# Footing

APPROVED  
Limited building only review  
Permit holder responsible for  
full compliance with the code.

Footing

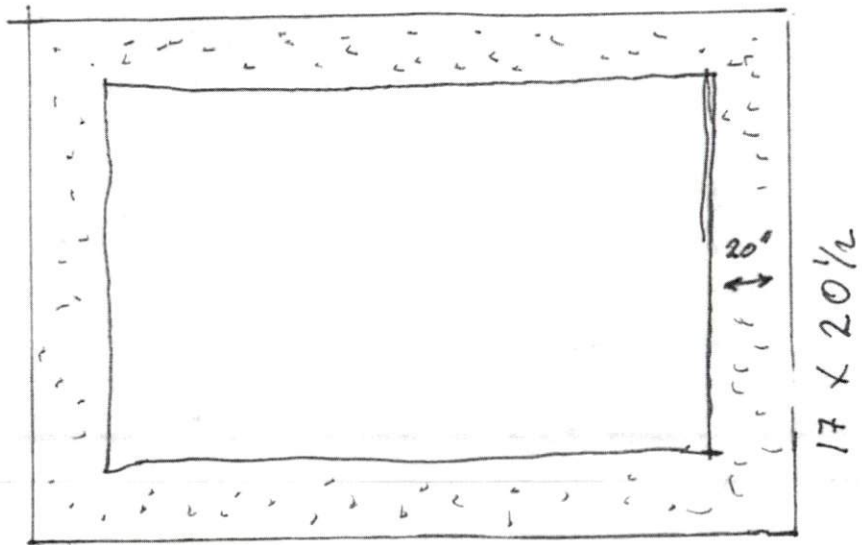
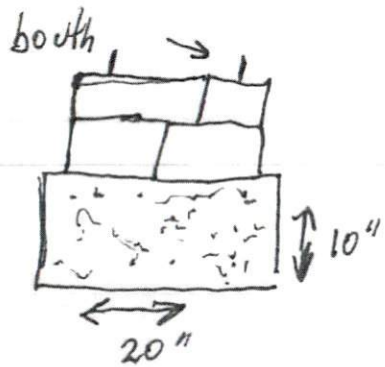
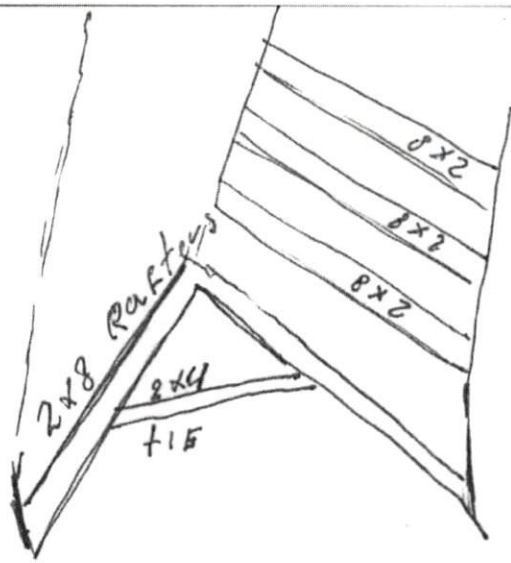
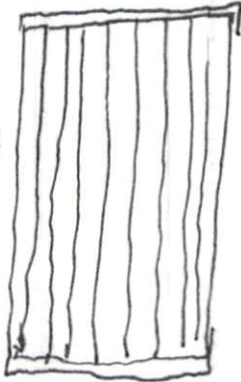
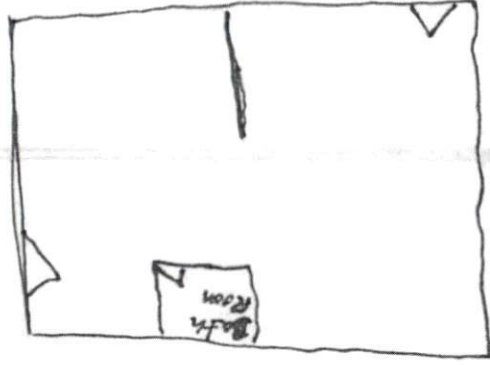
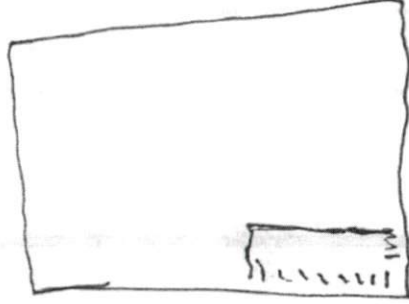
Add piers and footings for  
floor girder. All framing to  
be 16" oc max
